Subject: FW: LU/370/19/PL

I have started looking at the application you have in for 49 Horsham Road (ref: LU/370/19/PL). There appear to be a number of discrepancies in the plans that I am hoping you are able to iron out for me so I can have a look at the application in greater depth and get a decision to you as soon as possible. On the site plan there is clearly a structure to the rear of the shop, then on the location plan the structure is largened with the addition of a pitch roof and connected to the shop itself (I am assuming this is the actual proposal). However, this is where I gain my first confusion, having been on the site visit there is an existing structure with a pitched roof, is this to be demolished to incorporate the larger scheme? The floor plans the add an extra element of confusion illustrating there is no current structure in the 'Yard'. Then on the elevations as

PROPOSED GROUND FLOOR PLAN.
(1:100)

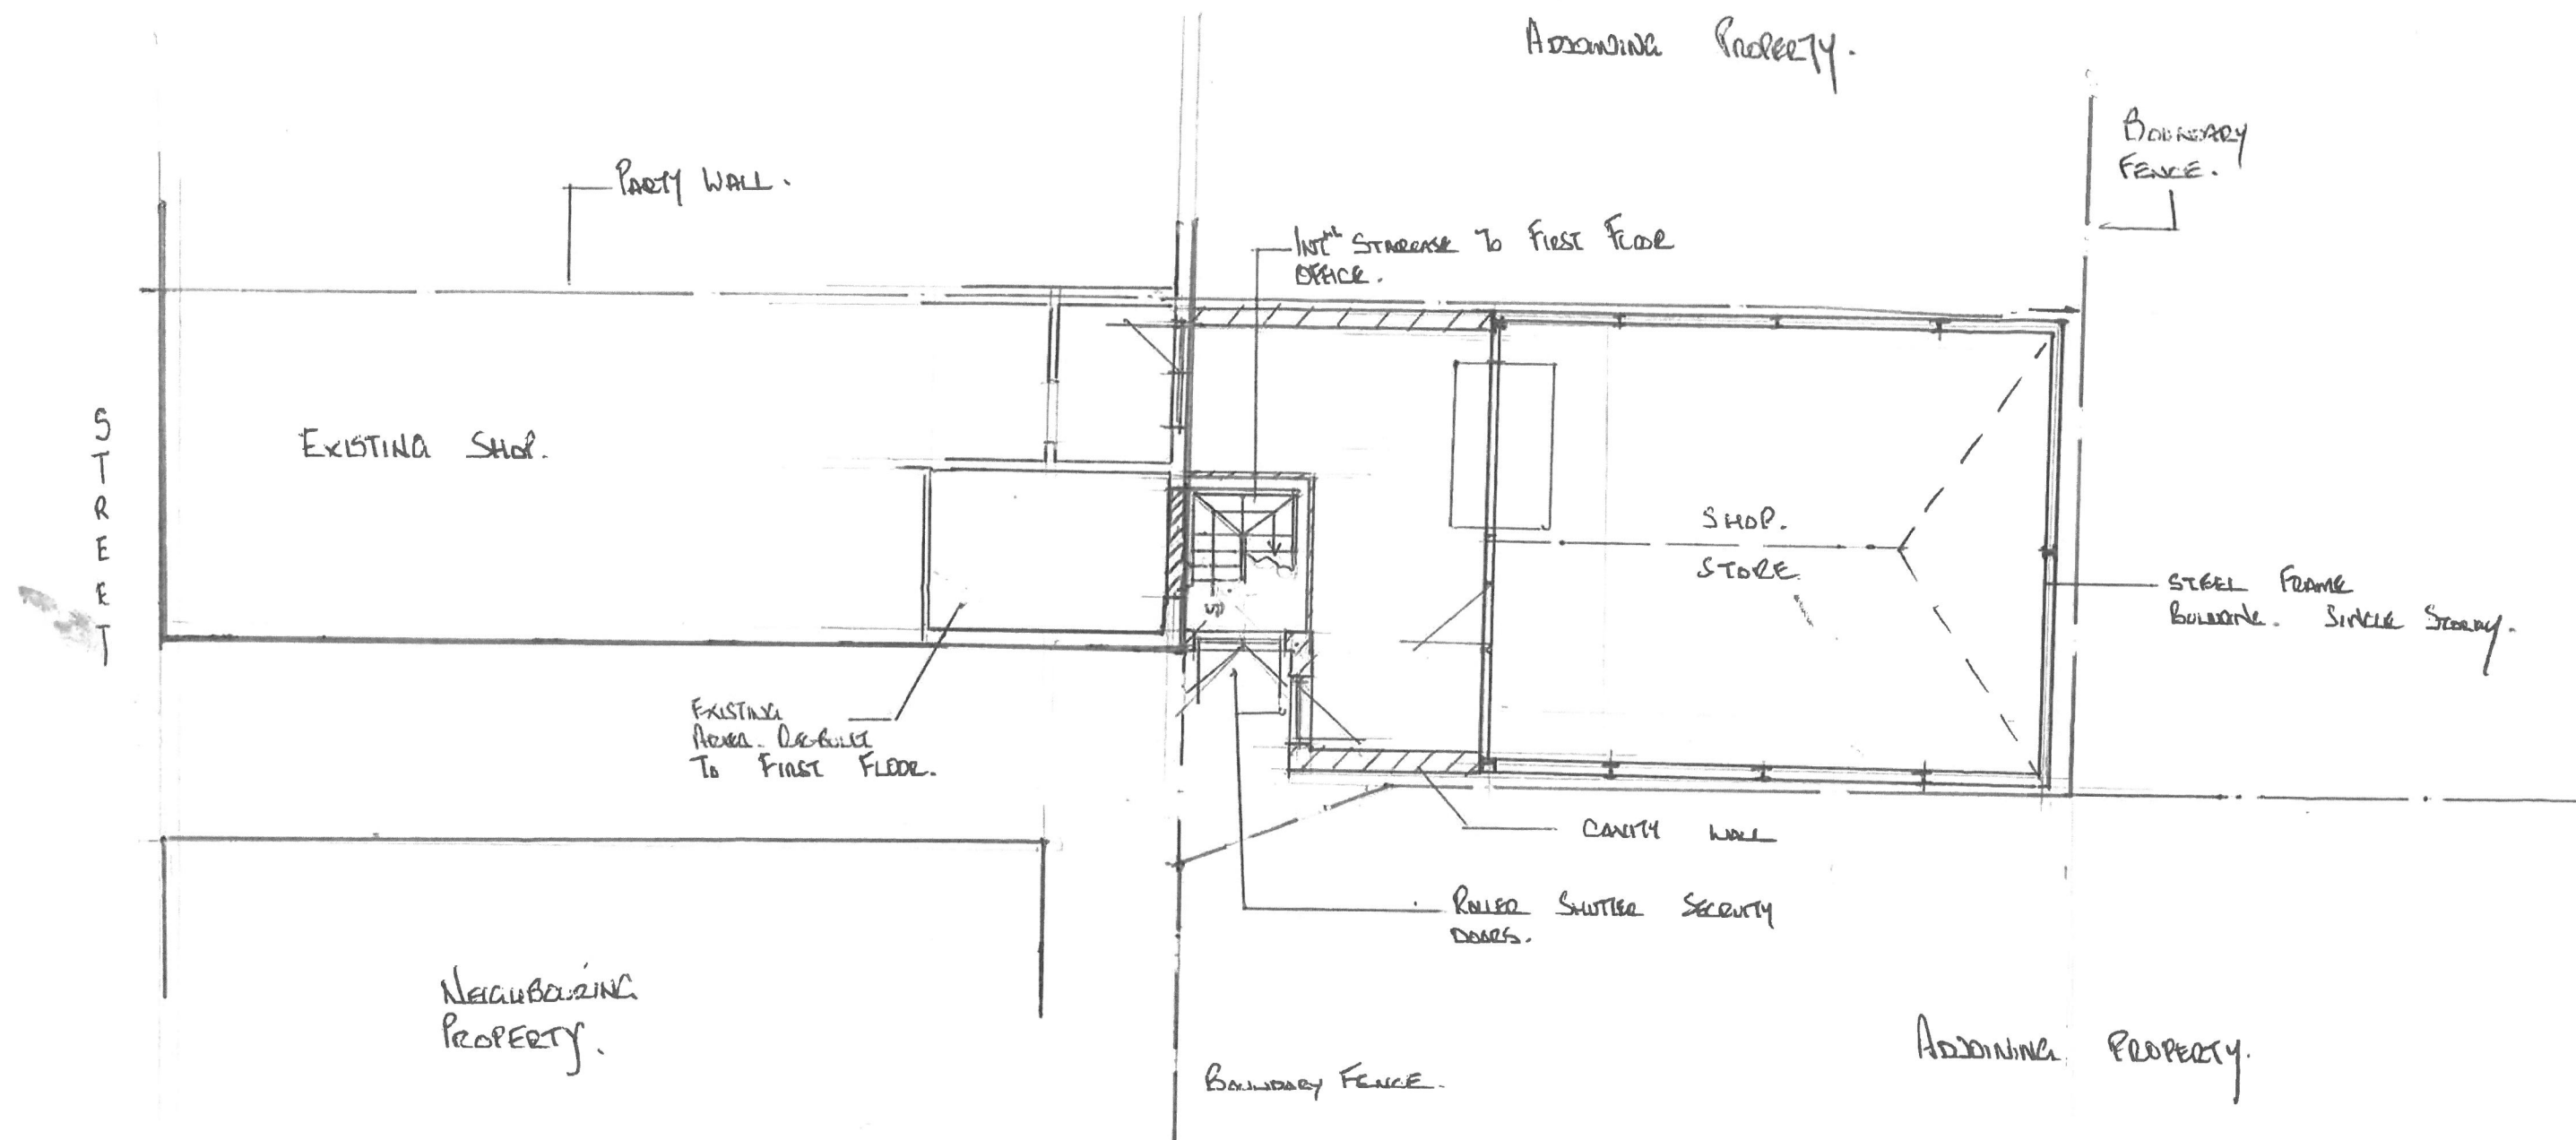
existing there is a flat rooved extension that connects to the shop and spans the complete depth to the rear. Finally the proposed internal stair case appears to be in the new single storey flat rooved rear extension leading me to be a little confused as to how that would work?
